14 July 2014

Our ref: 214.203L2

**RE: REQUEST UNDER SCHEDULE 6A "TRANSITIONAL
ARRANGEMENTS – REPEAL OF PART 3A' OF THE ENVIRONMENT
PLANNING AND ASSESSMENT ACT, 1979 (AS AMENDED)

MINOR MODIFICATION OF MAJOR PROJECT APPLICATION NO.
06_0025 (MOD 5) – VINCENTIA DISTRICT TOWN CENTRE –
"MODIFICATION 6"**

1 ELEVATION
WEST ELEVATION - MOONA CREEK ROAD

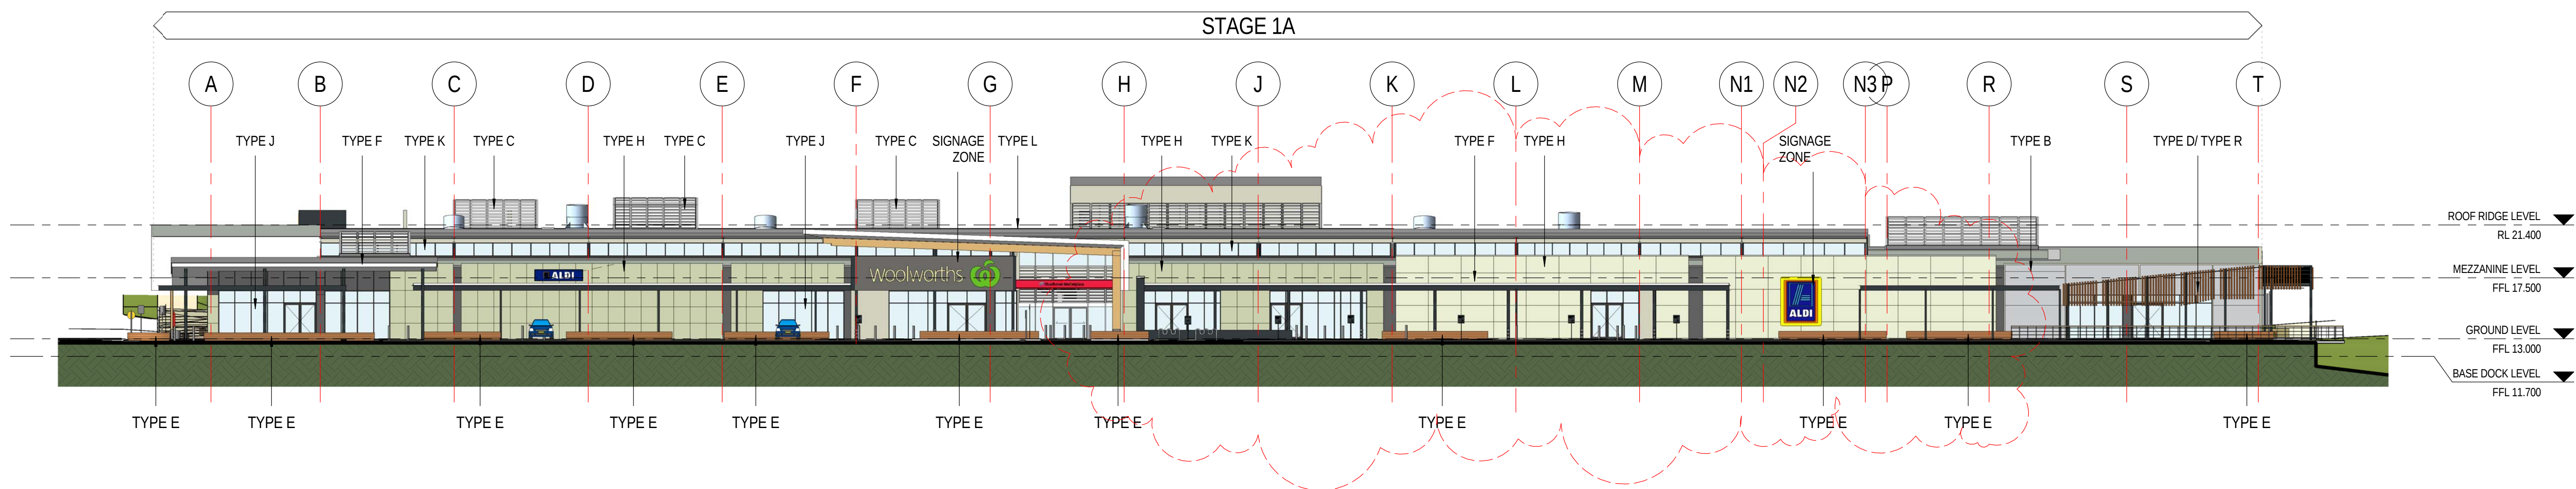
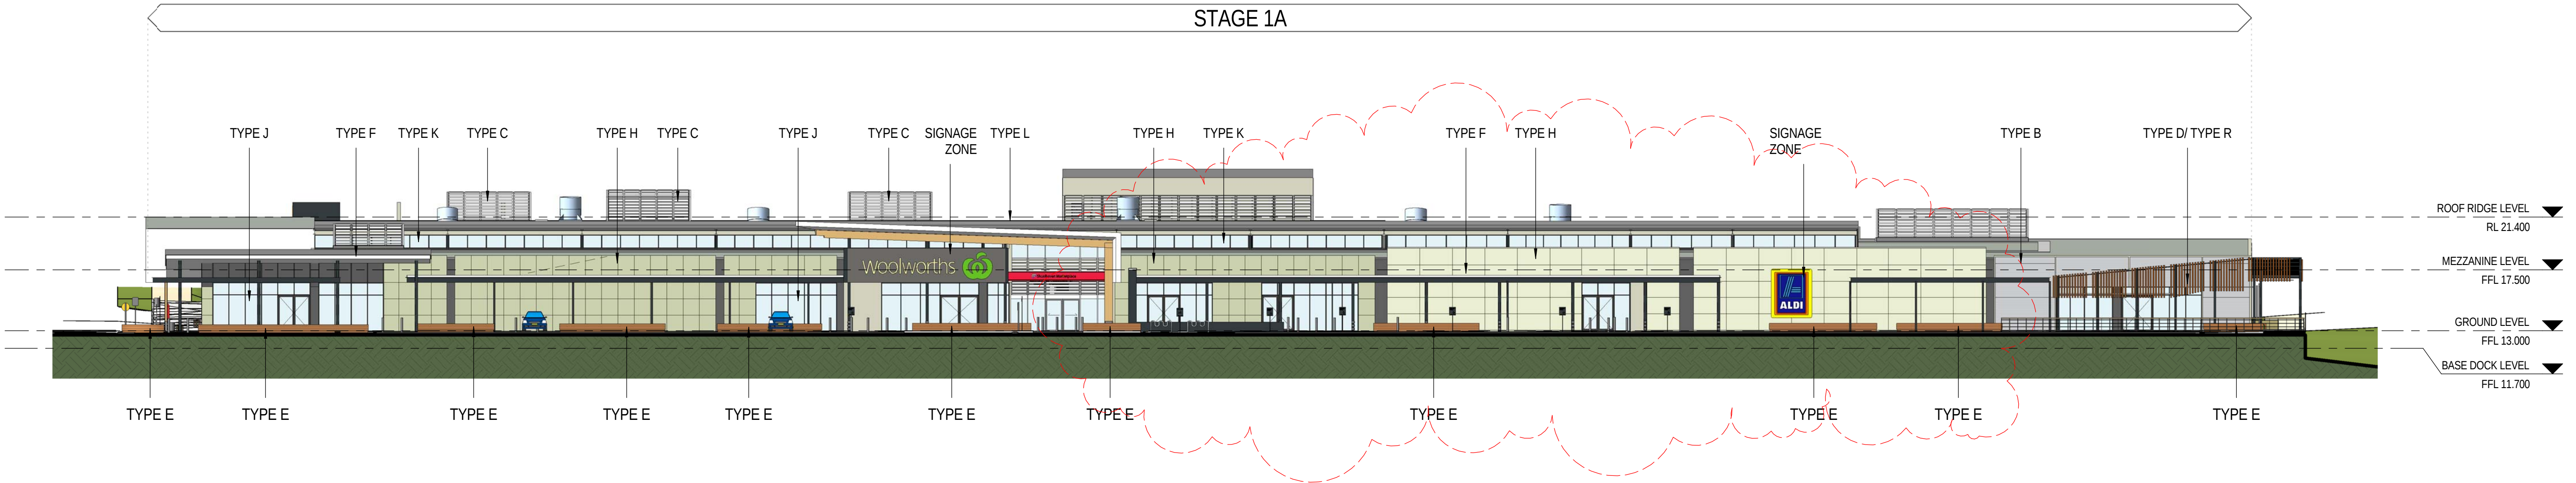
1. The proponent seeks to revise the staging of Stage 1 with the implementation of Stages 1a and 1b by:
 - a. deferring of the two (2) specialty shop tenancies at the Moona Creek Road frontage to Stage 1b;
 - b. deferring the angled parking spaces along Moona Creek Road to Stage 1b;
 - c. reducing the extent of the portion of Arbour Way not immediately required for the loading dock access to Stage 2;
 - d. Reducing the amount of car spaces in Parking Area 4 and Parking Area 3 and associated reconfiguration as follows:
 - i. Merging the car parks into one to form one consolidated 'western car park', with a reduction of the total car spaces of the separated car parks from 274 spaces to 218 spaces by deferring 56 spaces to a later time (these deferred spaces are to be included as part of a separate DA process for Pad Site 2).
